Memo To: El Paso County Planning and Community Development

From: Core Engineering Group, LLC.

Subject: SF17-11 Carriage Meadows South at Lorson Ranch Filing No. 1 Final Plat 2nd Review - Response to Comments

Date: August 14, 2017

INSTALL CDOT TYPE 3 BARRICADES, 4 BARRICADES AT 8LF LONG

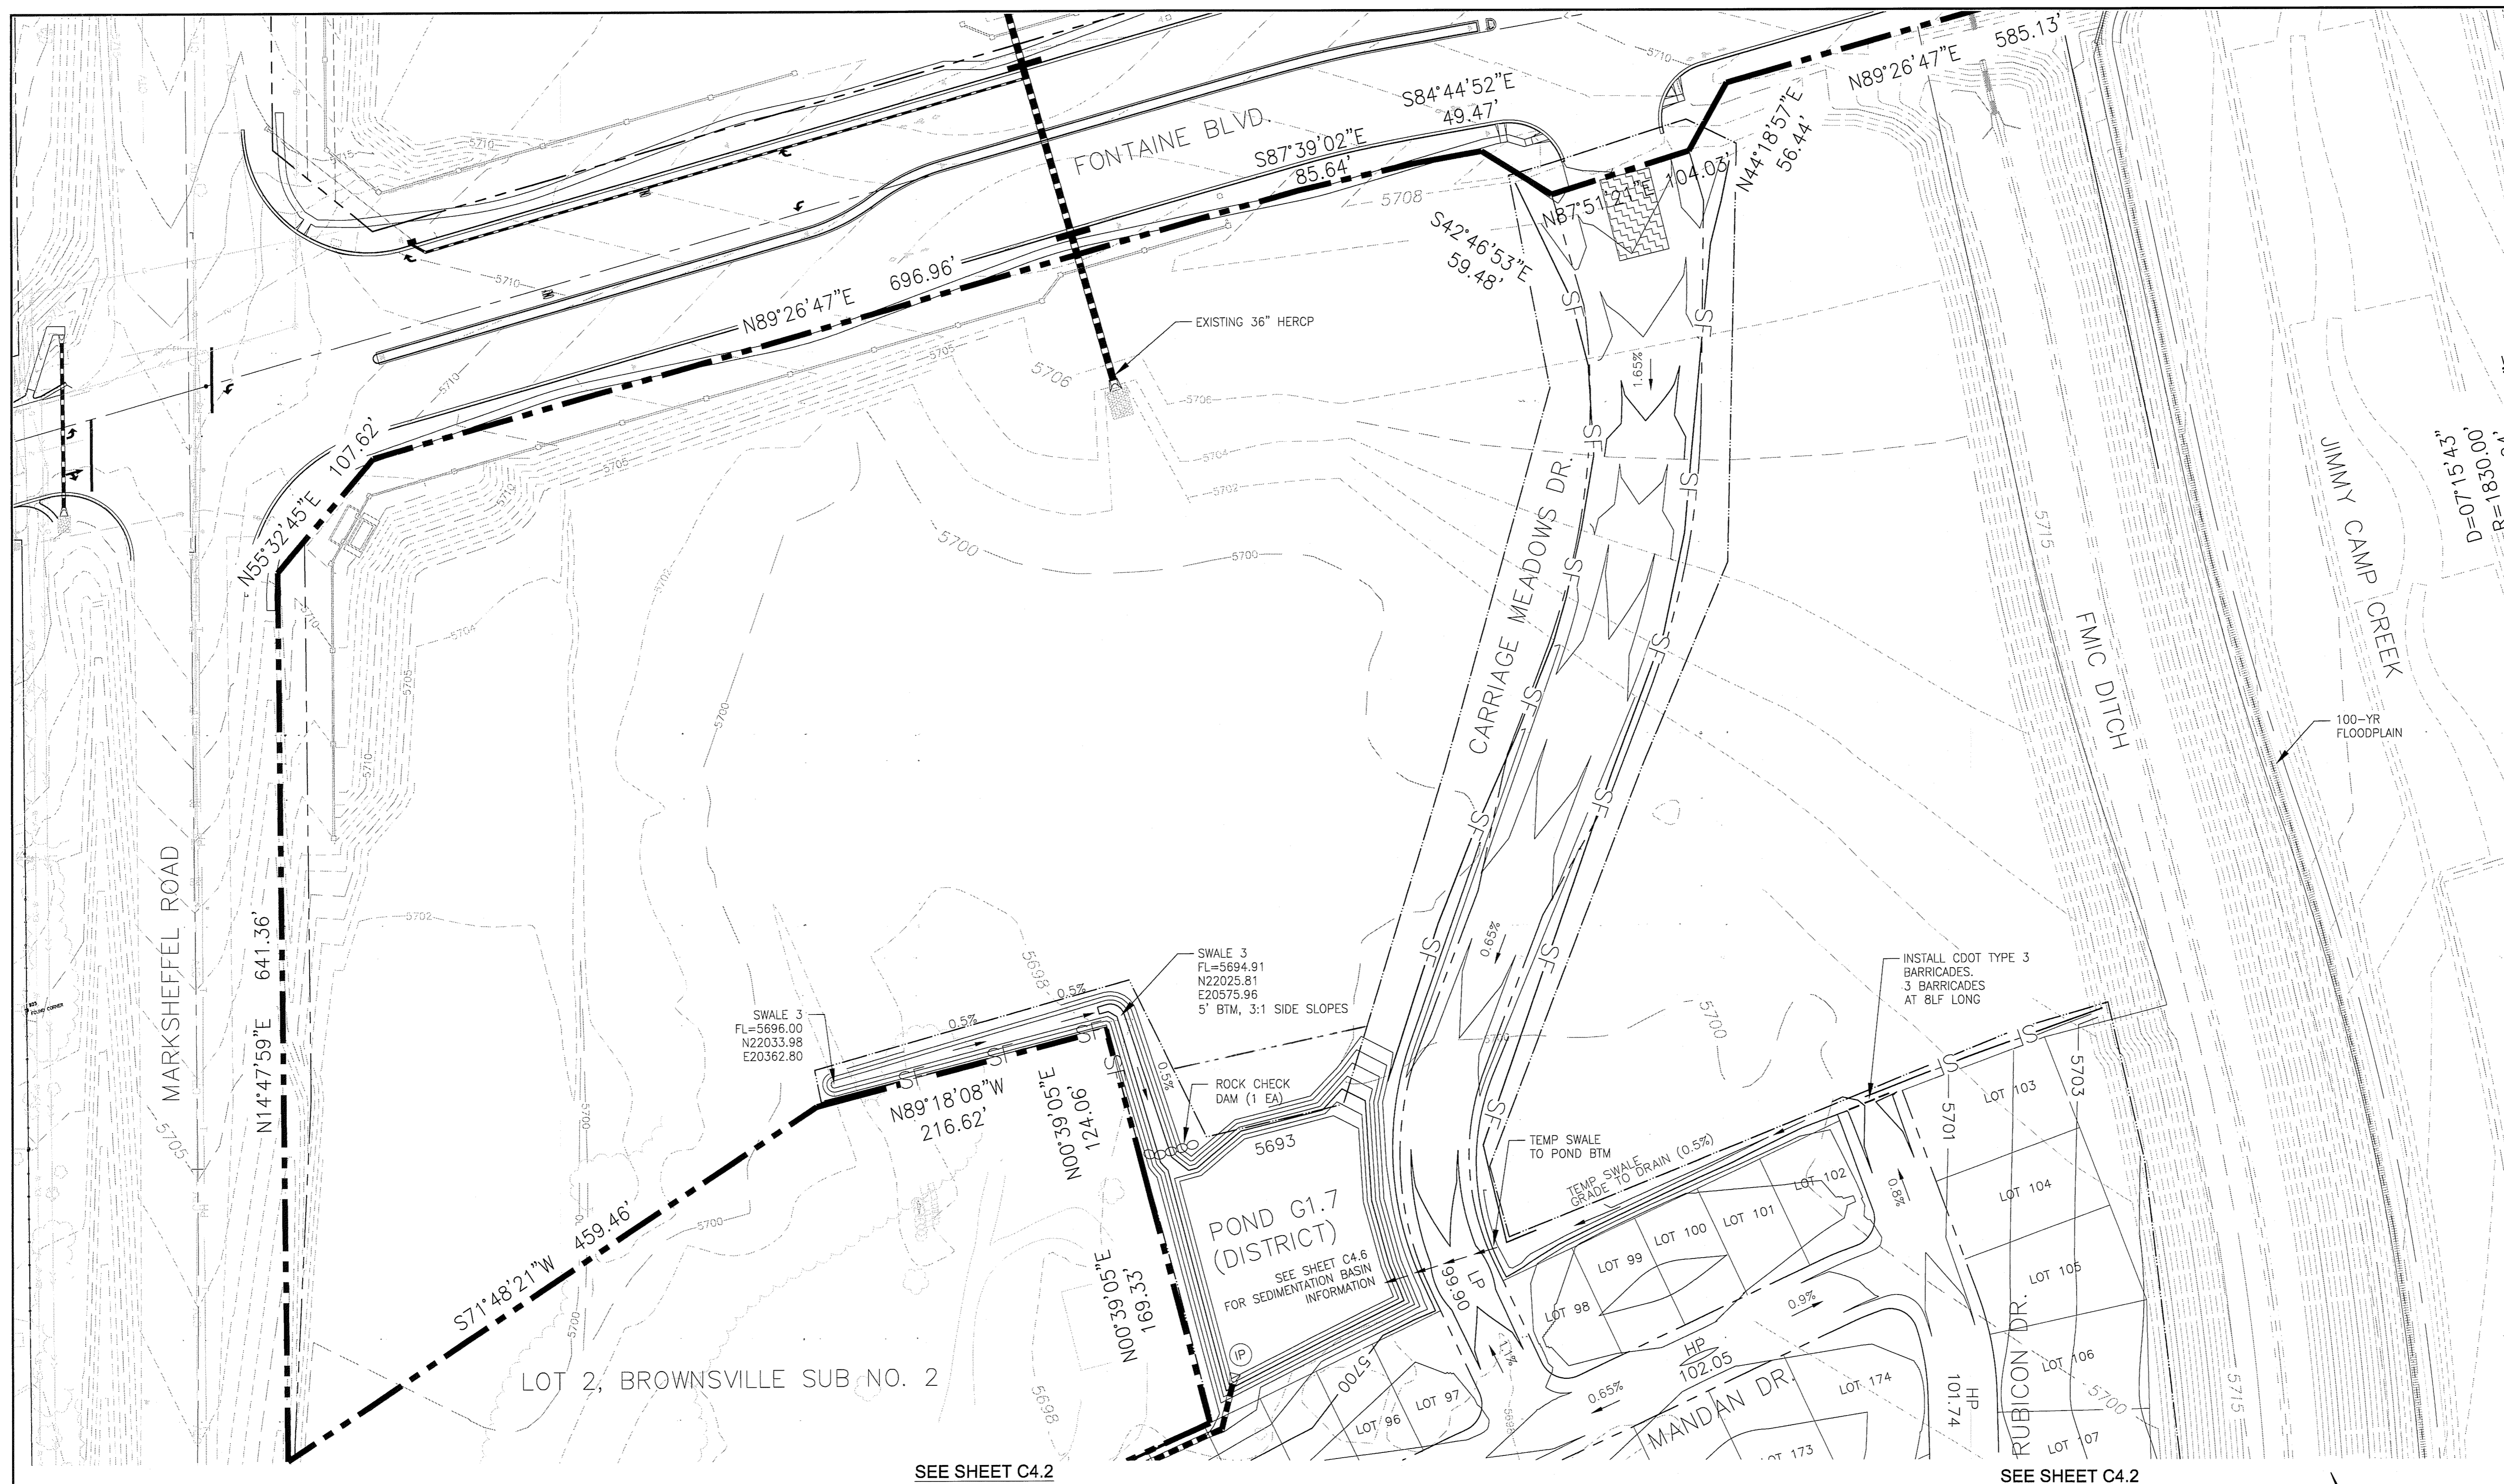
where are the CDOT type F barricades?

where are the CDOT type F barricades?

We added barricades here

(DISTRICT)
DETENTION POND G1.7
CARRIAGE MEADOWS SOUTH

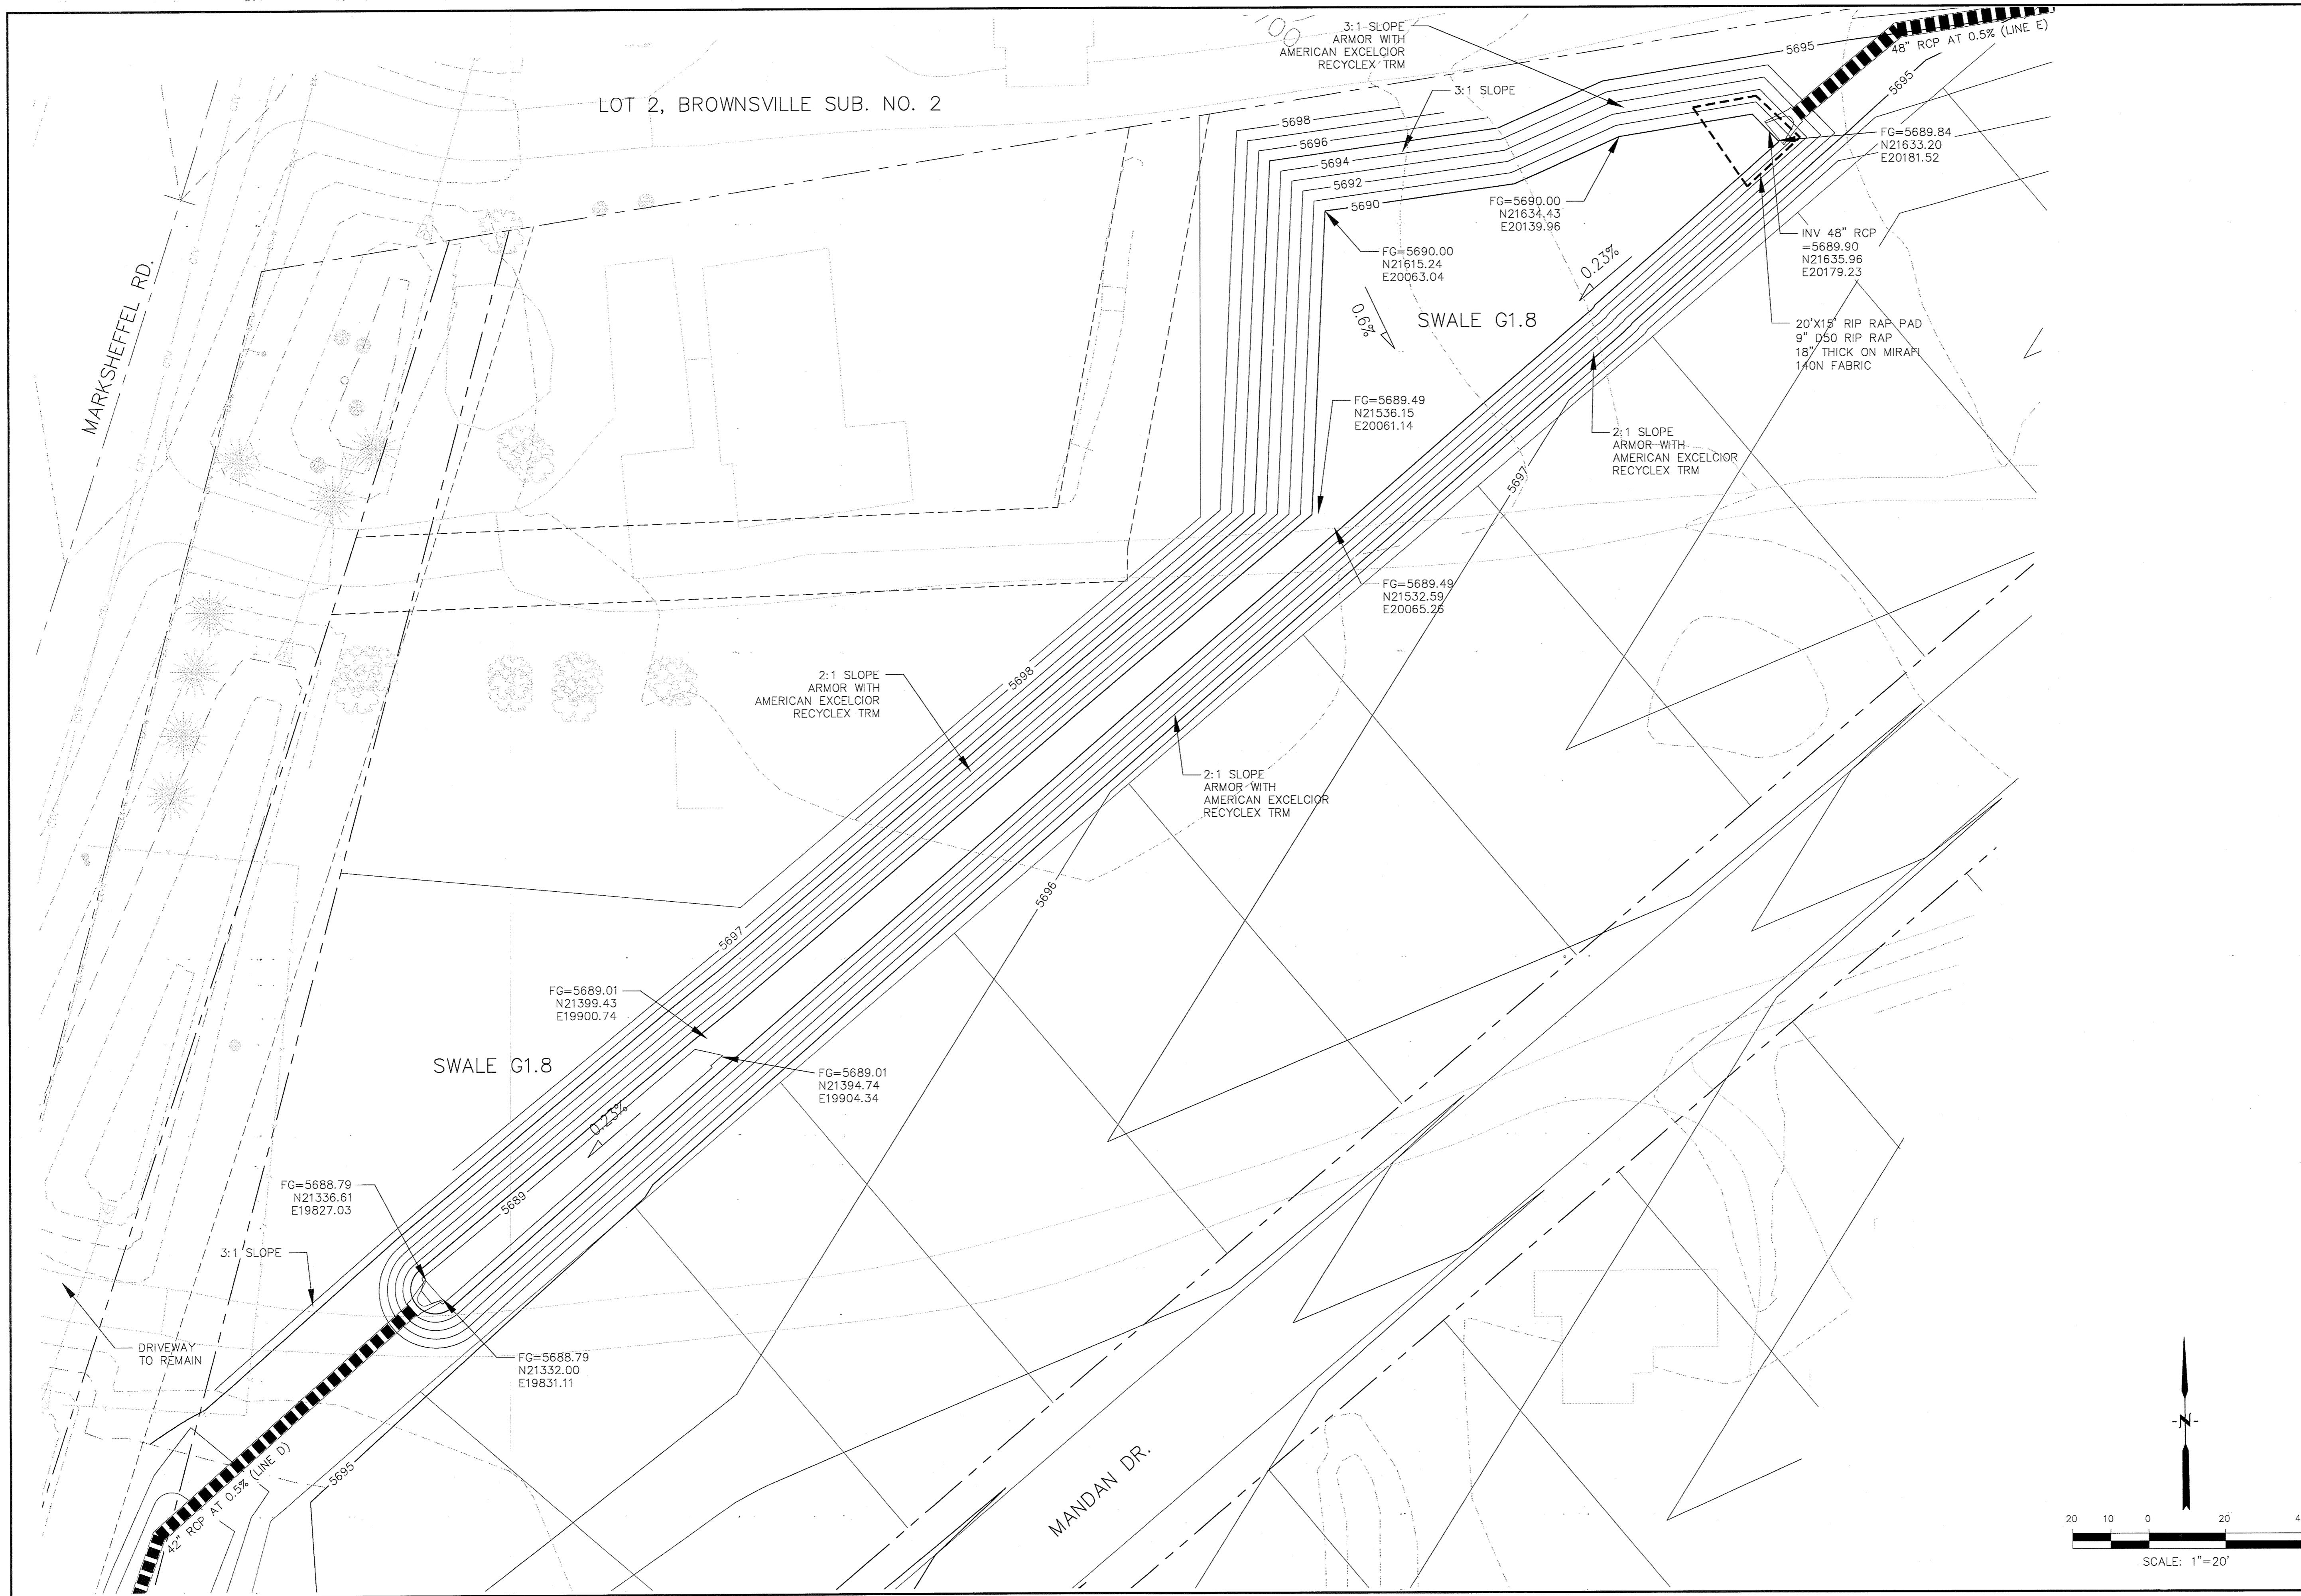
If pond G1.7 is intended to be interim, please state that the balance of the components needed to meet County Criteria must be installed at the time any developed flow enters this pond (otherwise, you must provide all of them in this development's GEC plan). All plans/documents should state that it is interim. (this is a cya for our MS4 permit)
